From: Kandi Talbot
To: Marge Schmuckal
Date: Thu, Nov 18, 1999 9:23 AM
Subject: 118 (Lot 4) Tucker Avenue Extension

332-B-16

JOB 78415 LOT 4 TUCKER WOODS

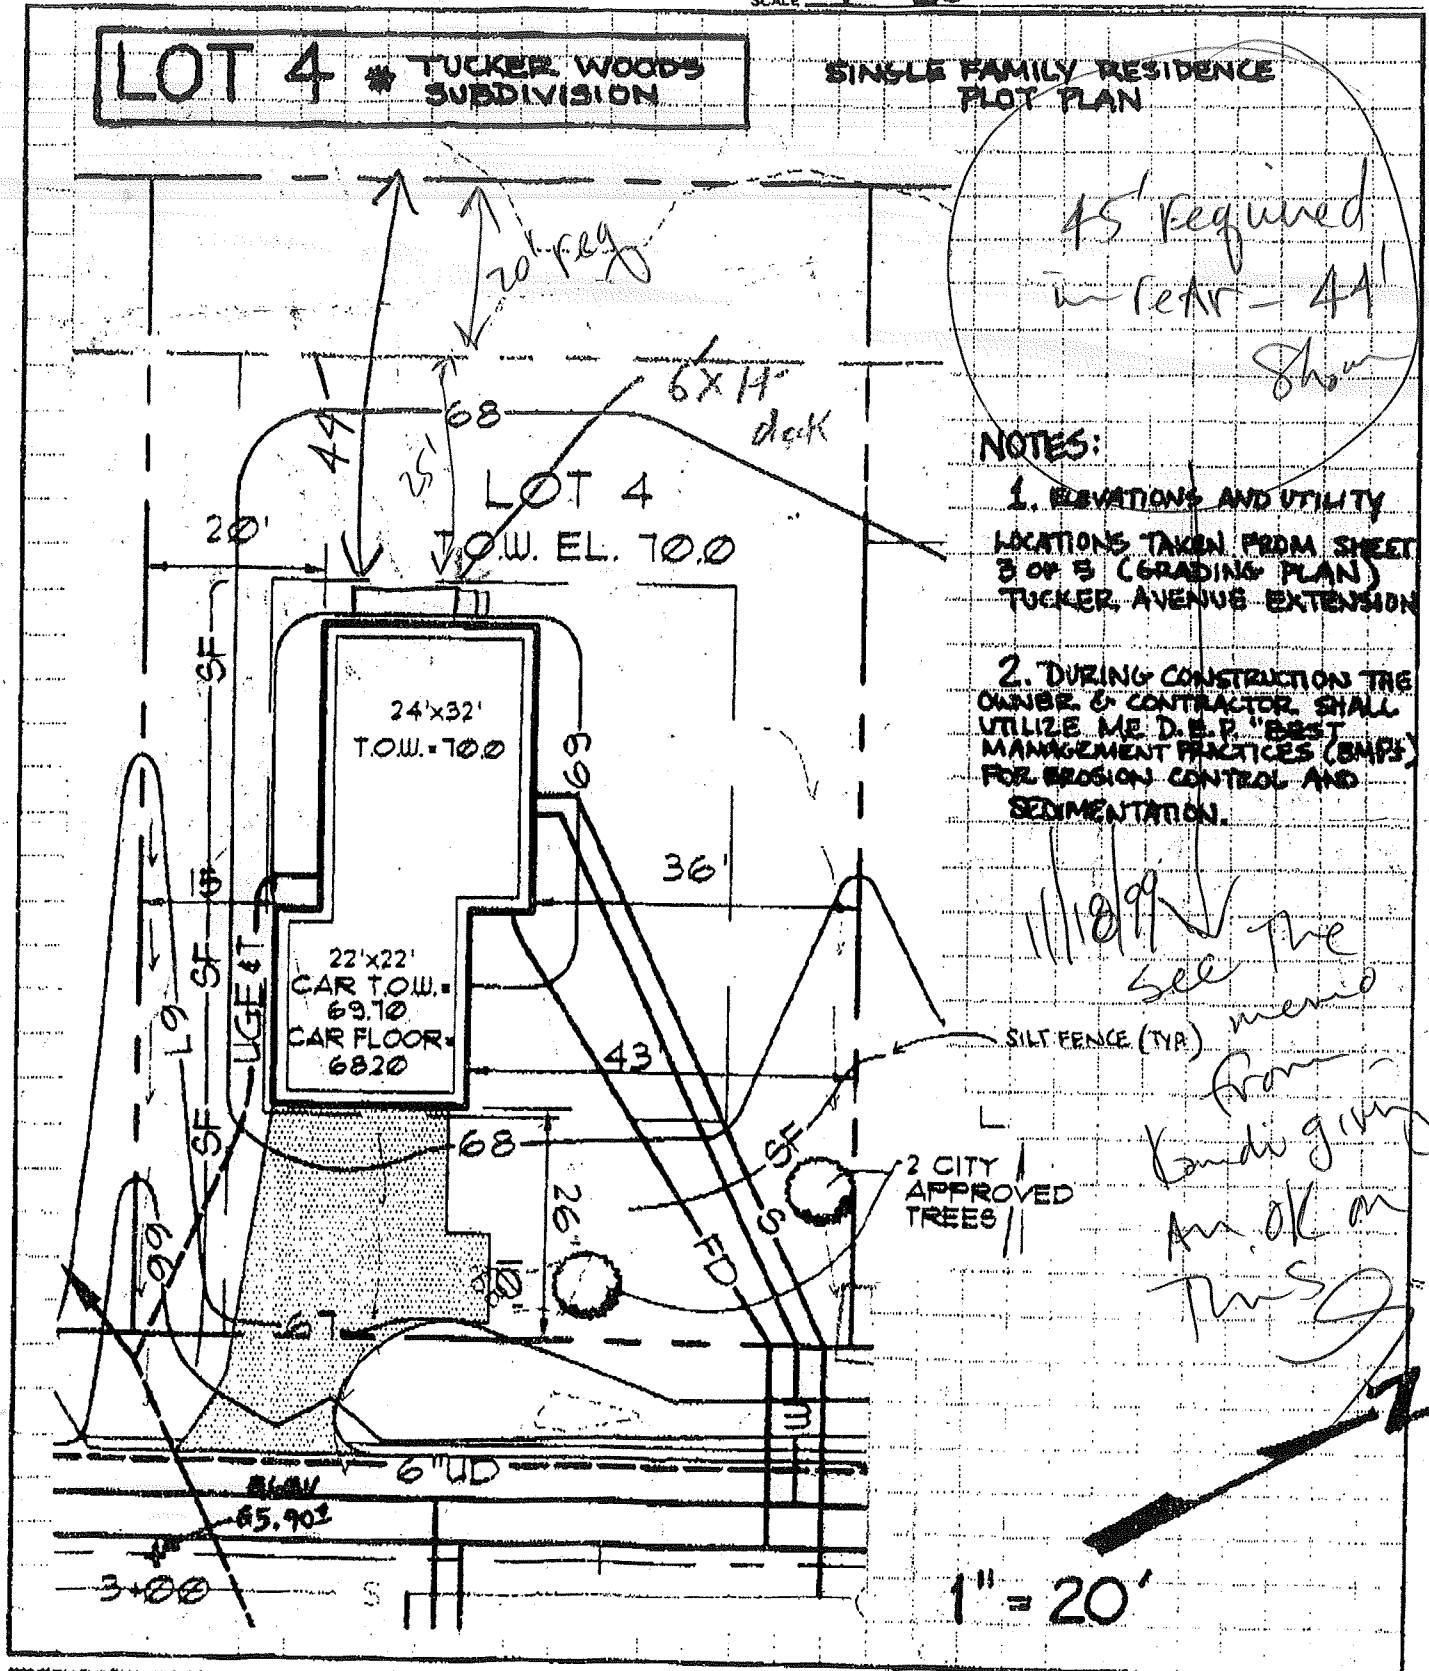
We have reviewed the deck and the request for the one foot past the building envelope as shown on the subdivision plan. Because of the "no-cut" buffer between Riverside Street and the house, we feel that one foot past the building envelope is acceptable, and is not a problem.
